**Consultation Response from KC,
Trees**

2024/91593 410, Birkby Road, Birkby, Huddersfield, HD2 2DN

Erection of detached outbuilding

Date Responded: 19/06/2024

client	MR R.HANDA		
project	PROPOSED STORE 410 BIRKBY ROAD HUDDERSFIELD HD2 2DN		
drawing	PROPOSED SITE PLAN		
revision	notes	date	drawn
scale :	1:200 AT A1	05.23	MG
project no.		drawing no.	revision
2165		01

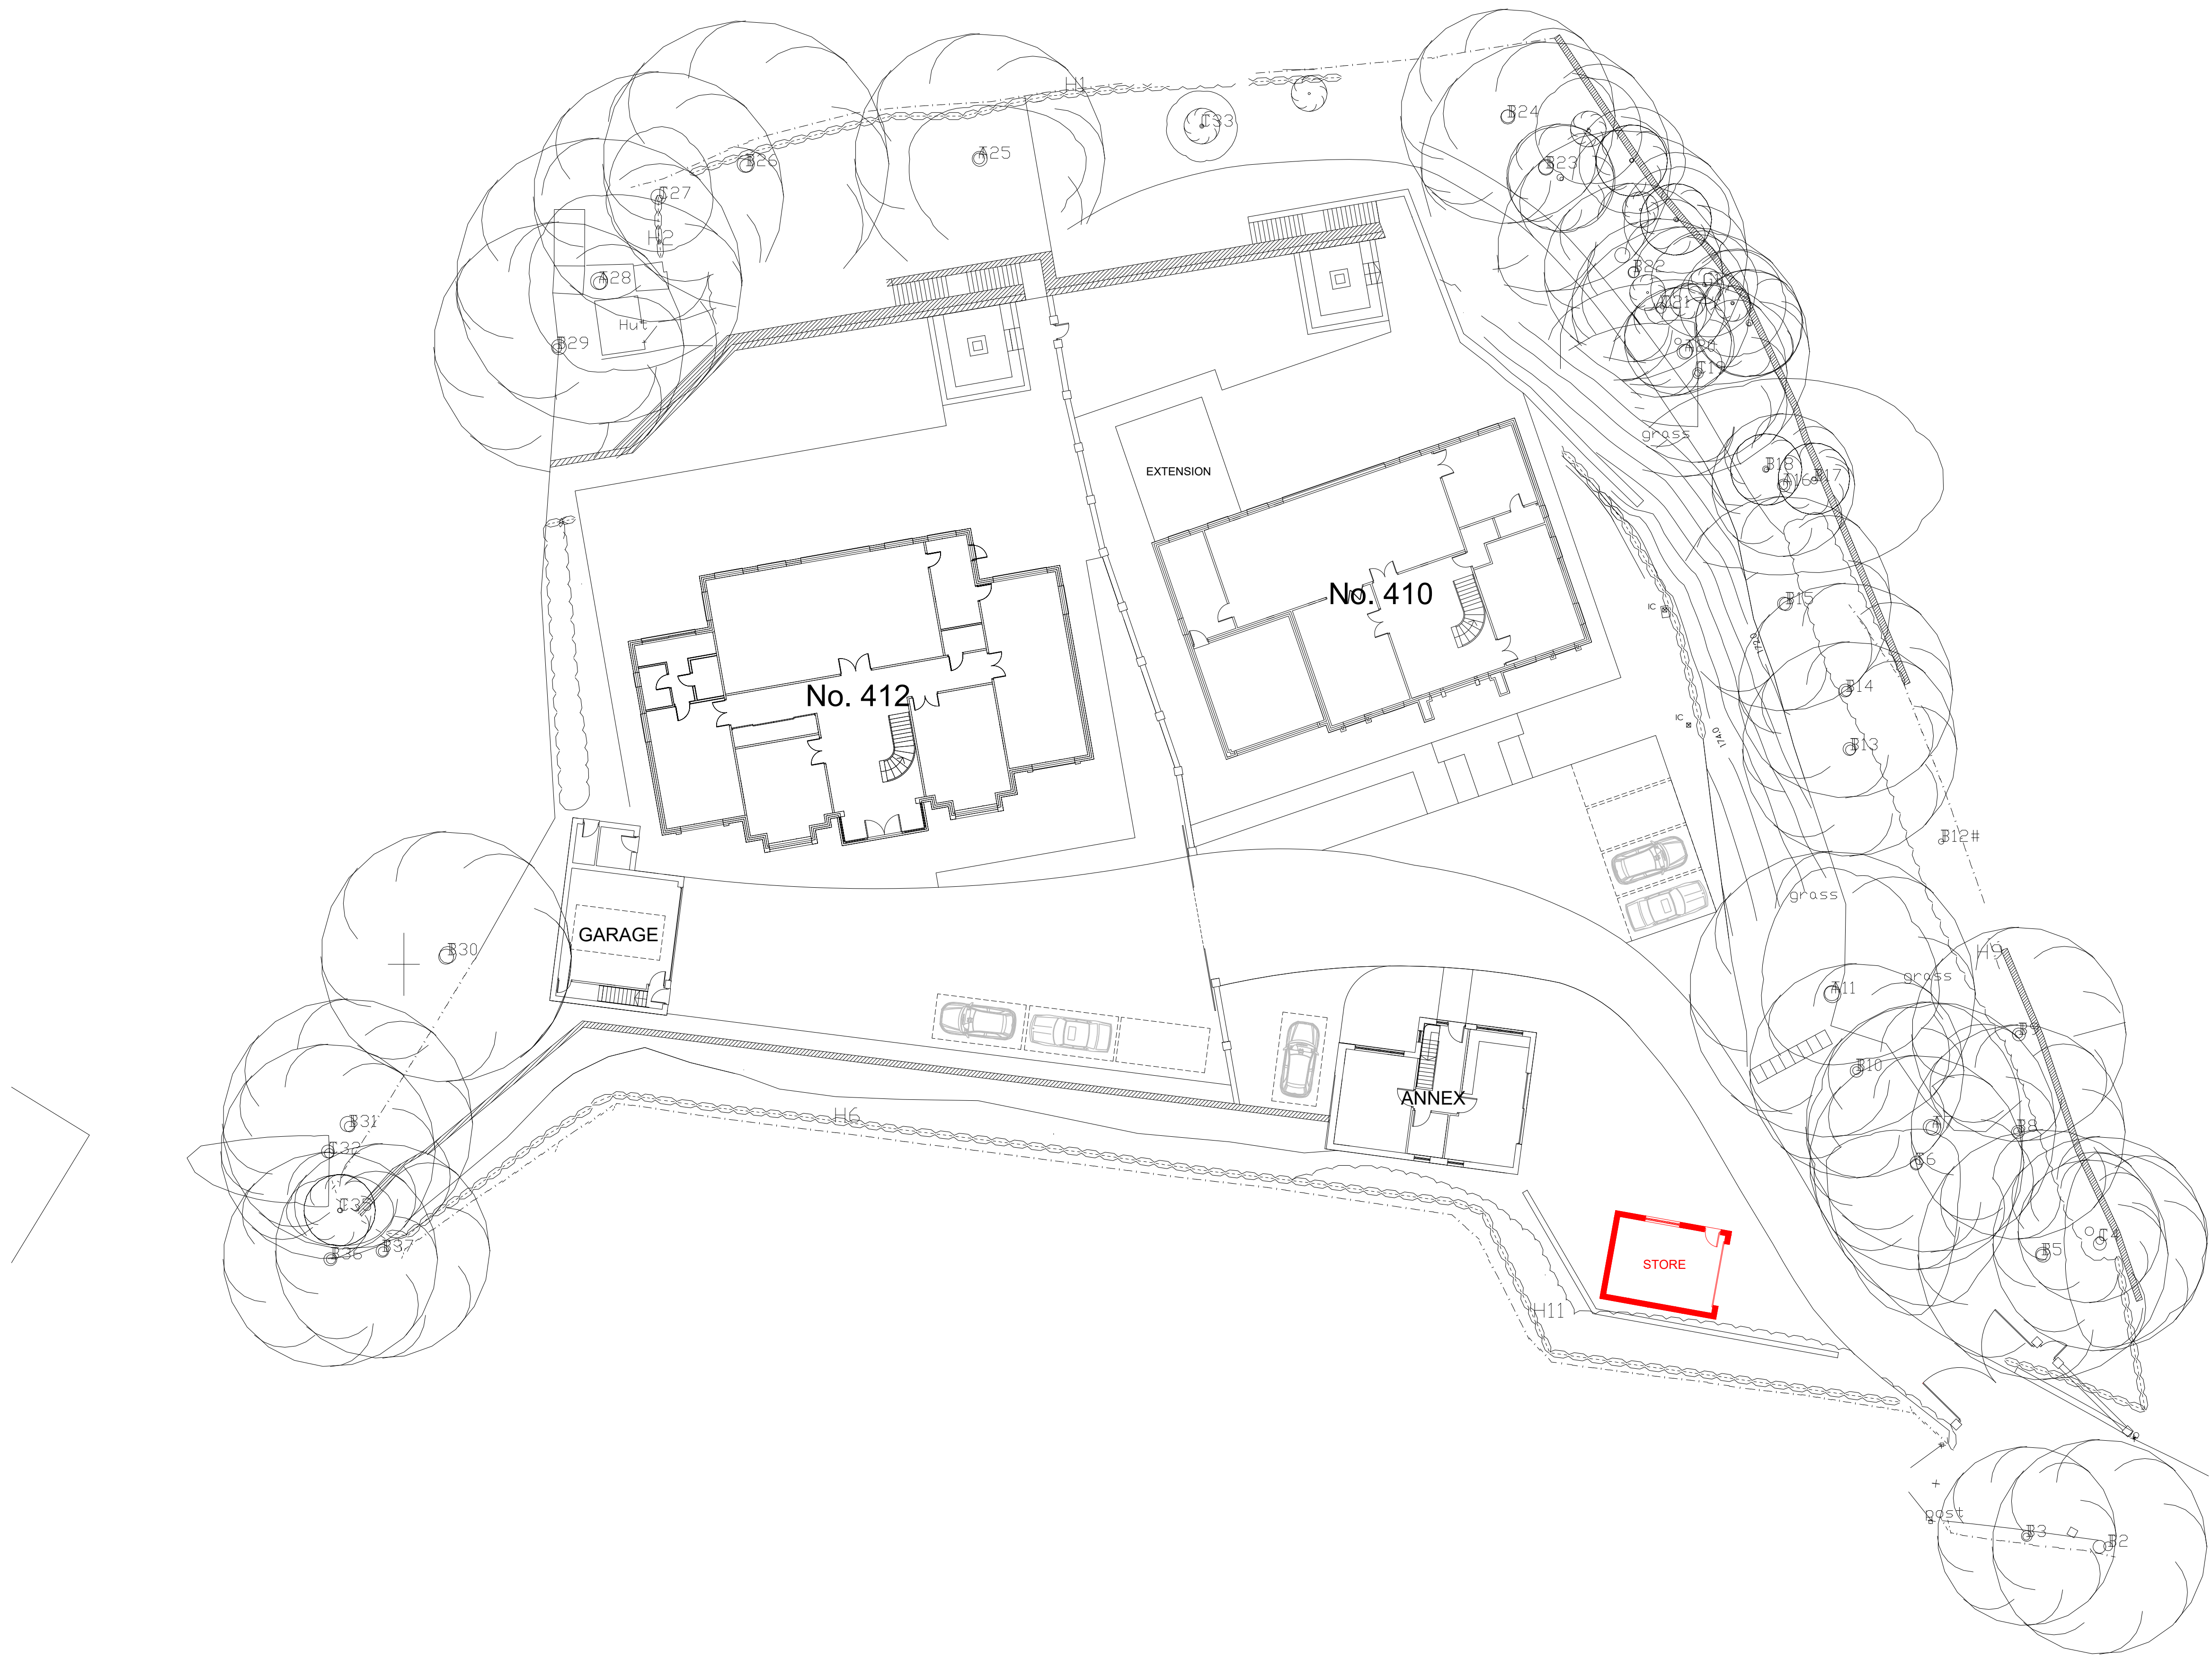
The site is heavily constrained by trees most of which are protected by TPO 14/75. There has been no tree information submitted and therefore I cannot judge the impact on the surrounding trees. There is a holding objection until an Arboricultural Impact Assessment and an Arboricultural method statement is submitted to show the impact on adjacent trees as well as how they will be protected during construction.
